Land at Woodgate Centre, Woodgate

20-061-016 Rev -

Response to WSCC Highways Comments

December 2021

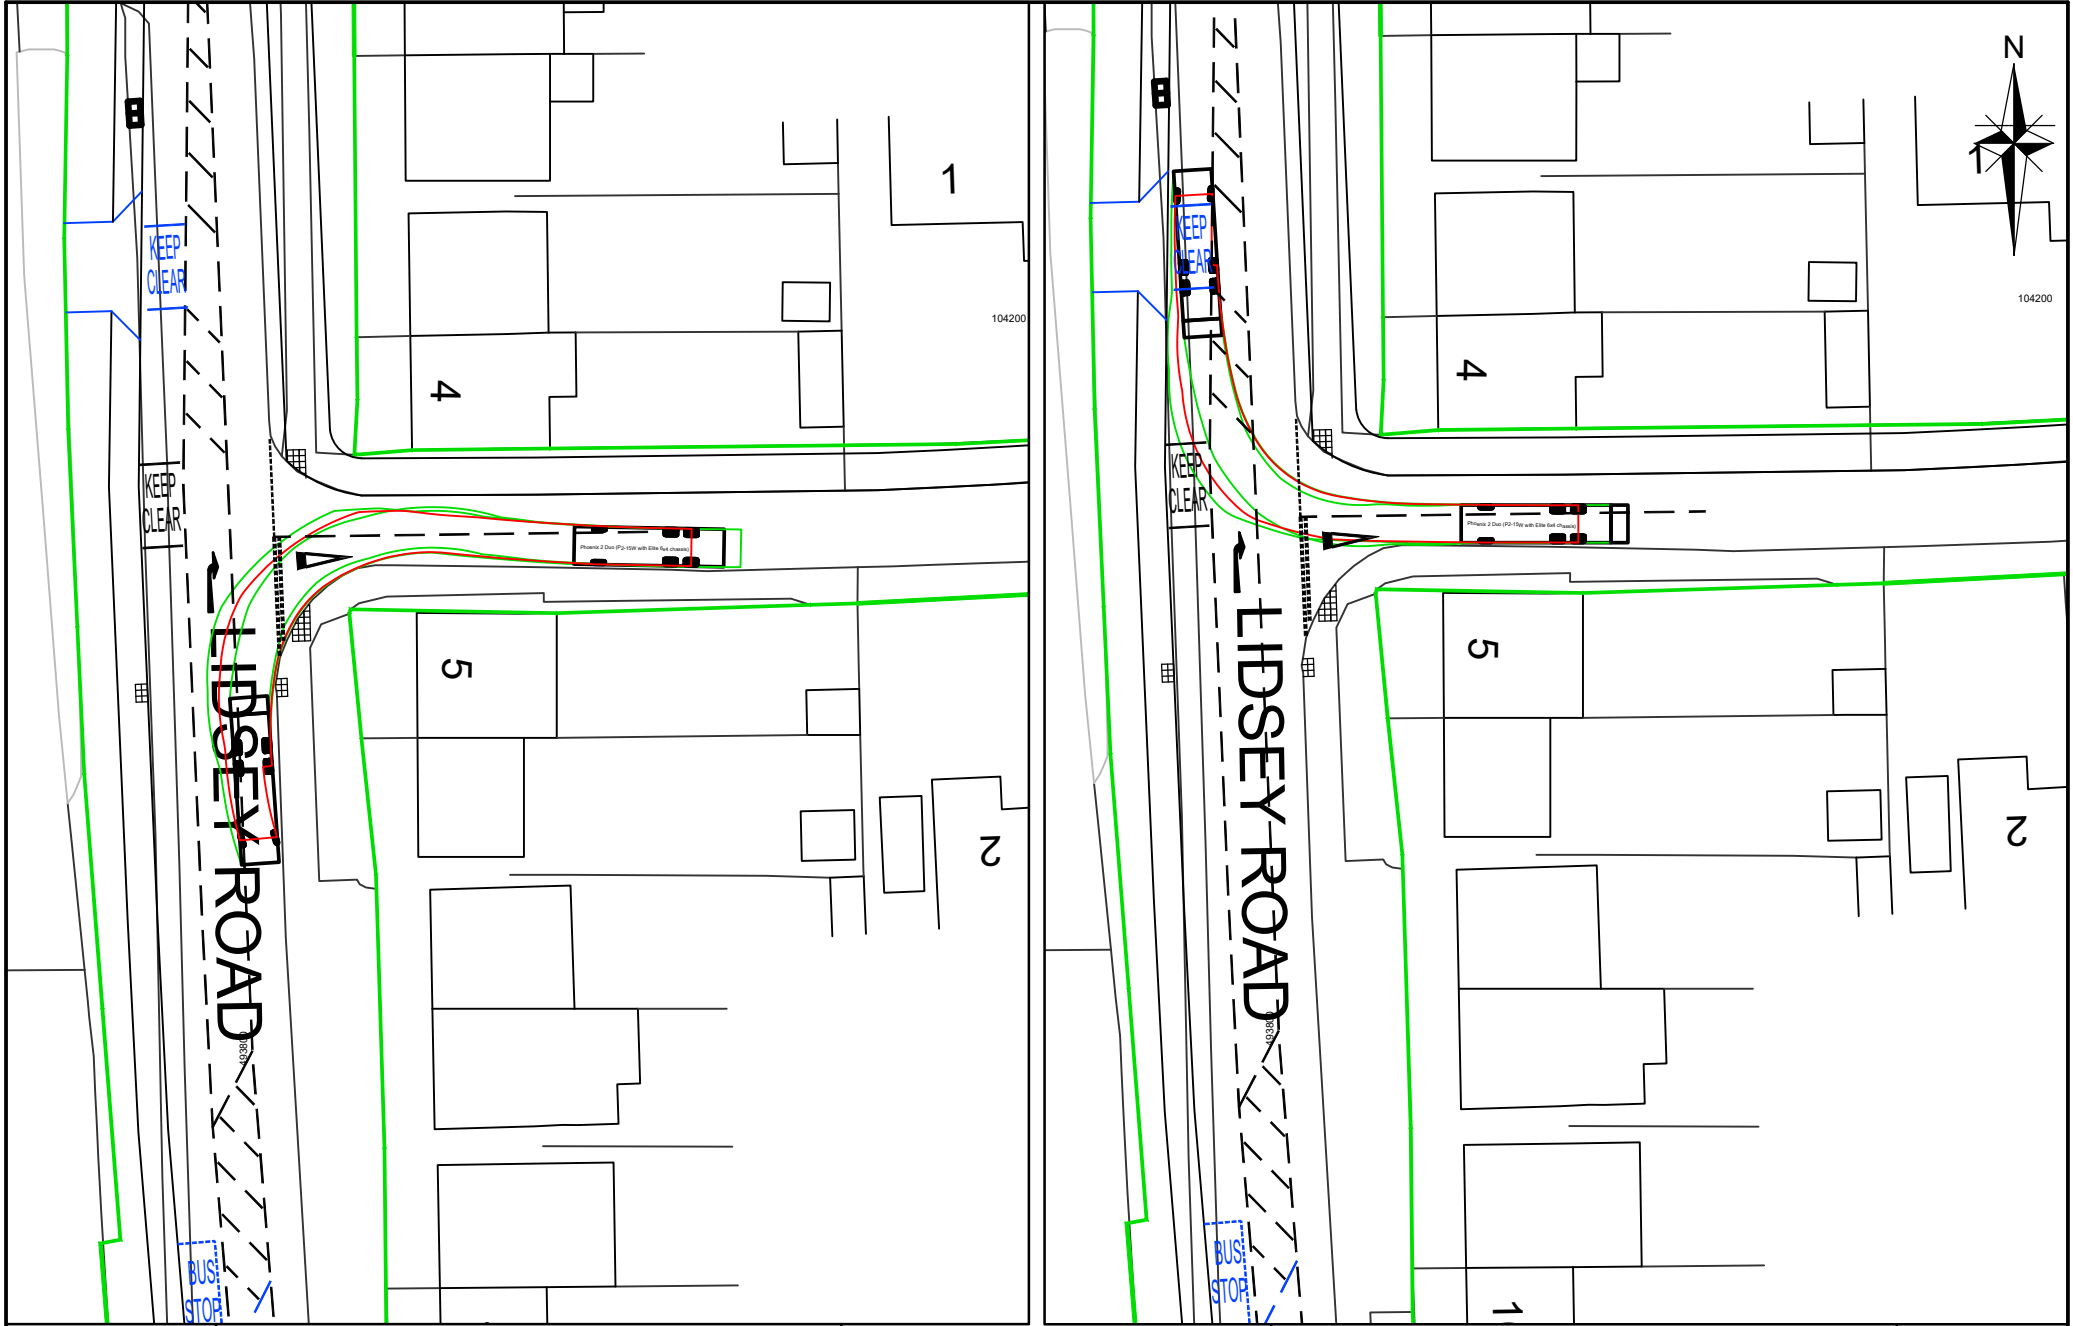
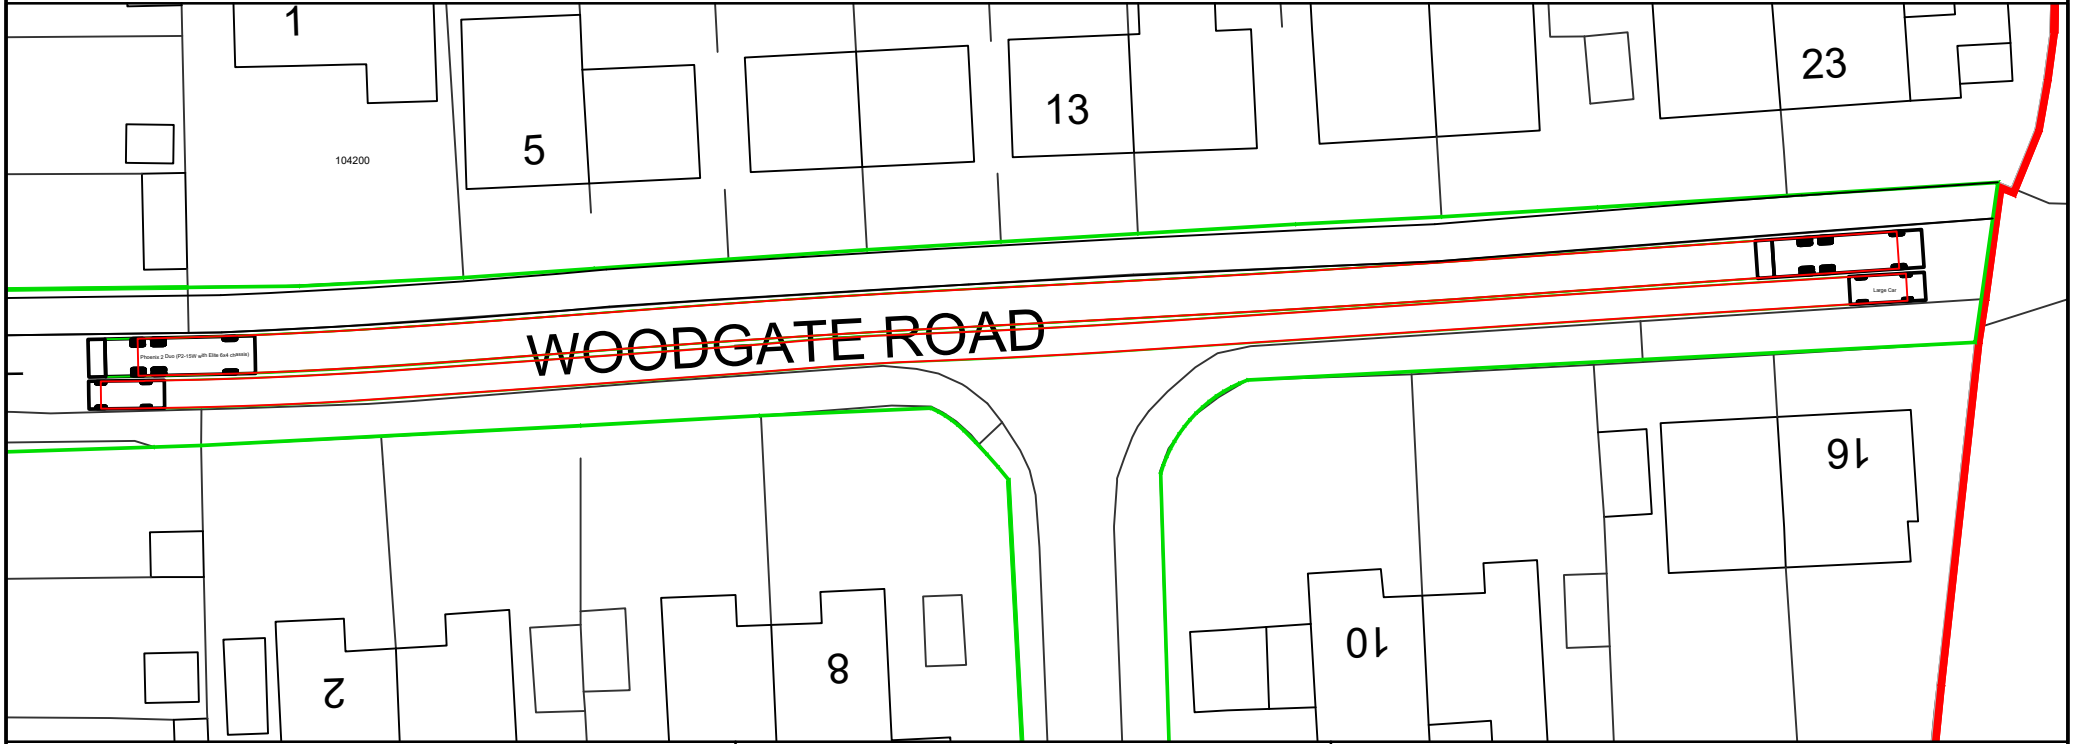
a plan showing queues on Woodgate Road when railway crossing gates are down and swept-path diagrams at junction with cars parked at the junction

- 3.1.9 An indication of how Woodgate Road might operate in these circumstances in terms of interaction with opposing and parked vehicles is shown on drawing 20-061/040, contained in **Appendix C**.

- 2.1.3 This is covered in more detail below (paragraphs 3.1.4 to 3.1.10), however drawing 20-061-040 (**Appendix C**) provides an indication of how Woodgate Road will operate in the circumstances detailed.
